109 East B. st, Erwin, Nc 28339

Word & Glory Church

Life Safety Plan

Reviewed for Code Compliance
03/10/2026

Word & Glory Church

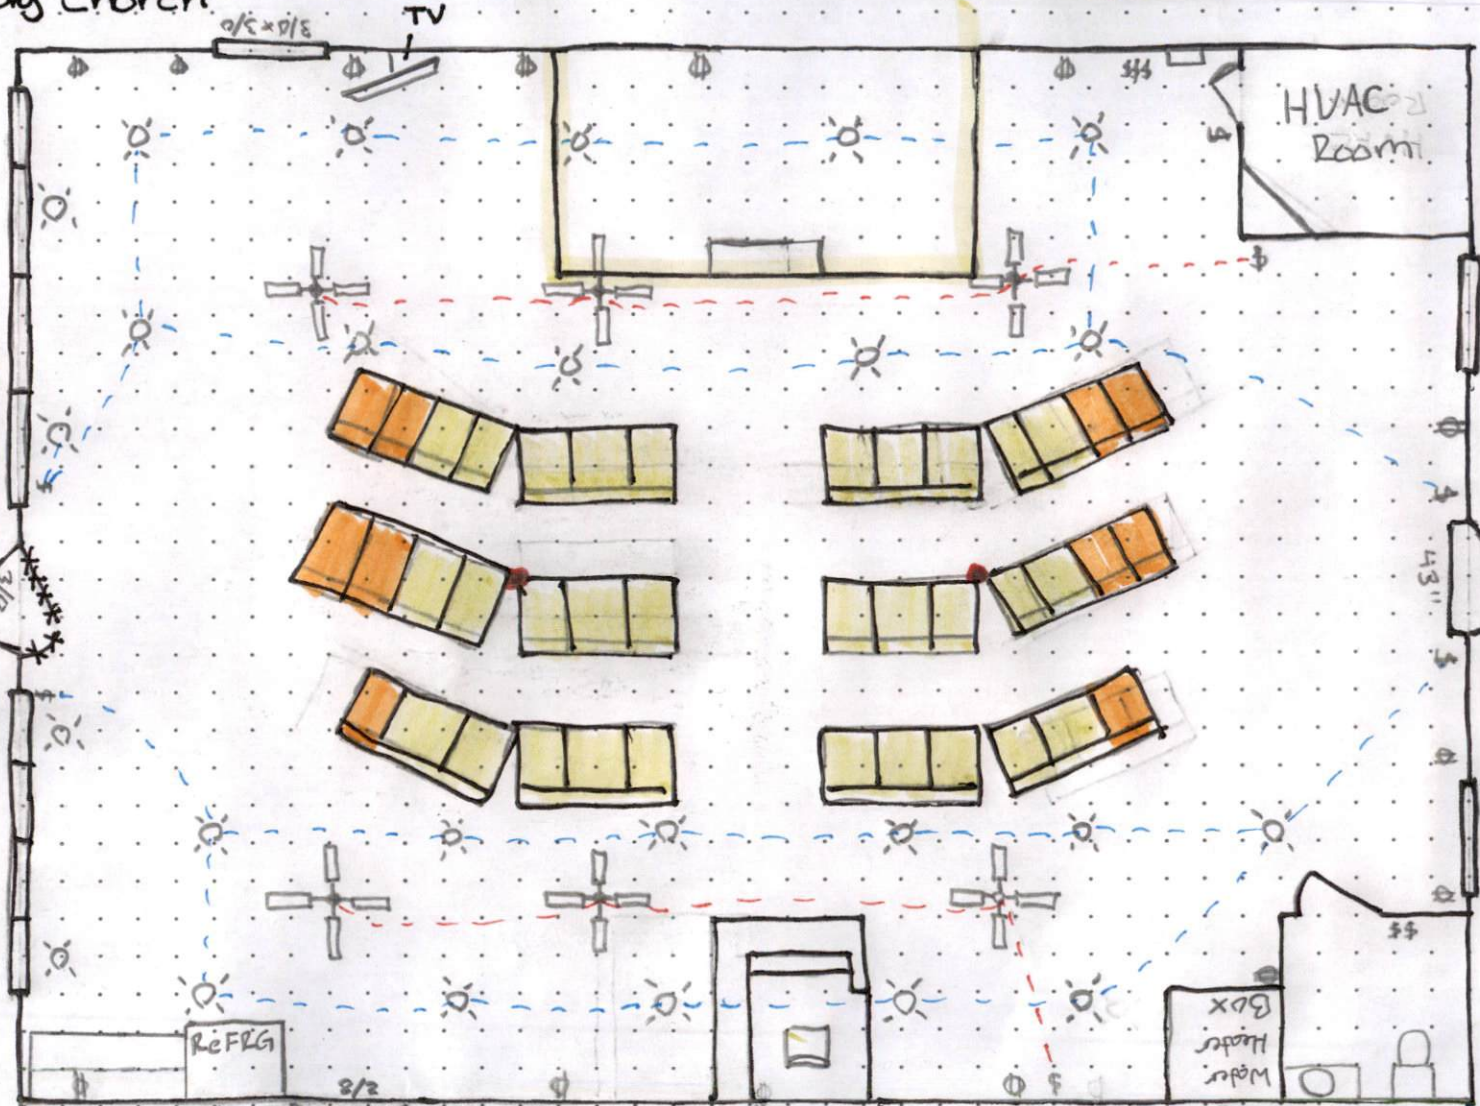
Calculated Occ load 172.

1200/7=171.42. Exits must have panic hardware. Must have exit lights and emergency lights.

Max occ load based on existing bathroom is 30.
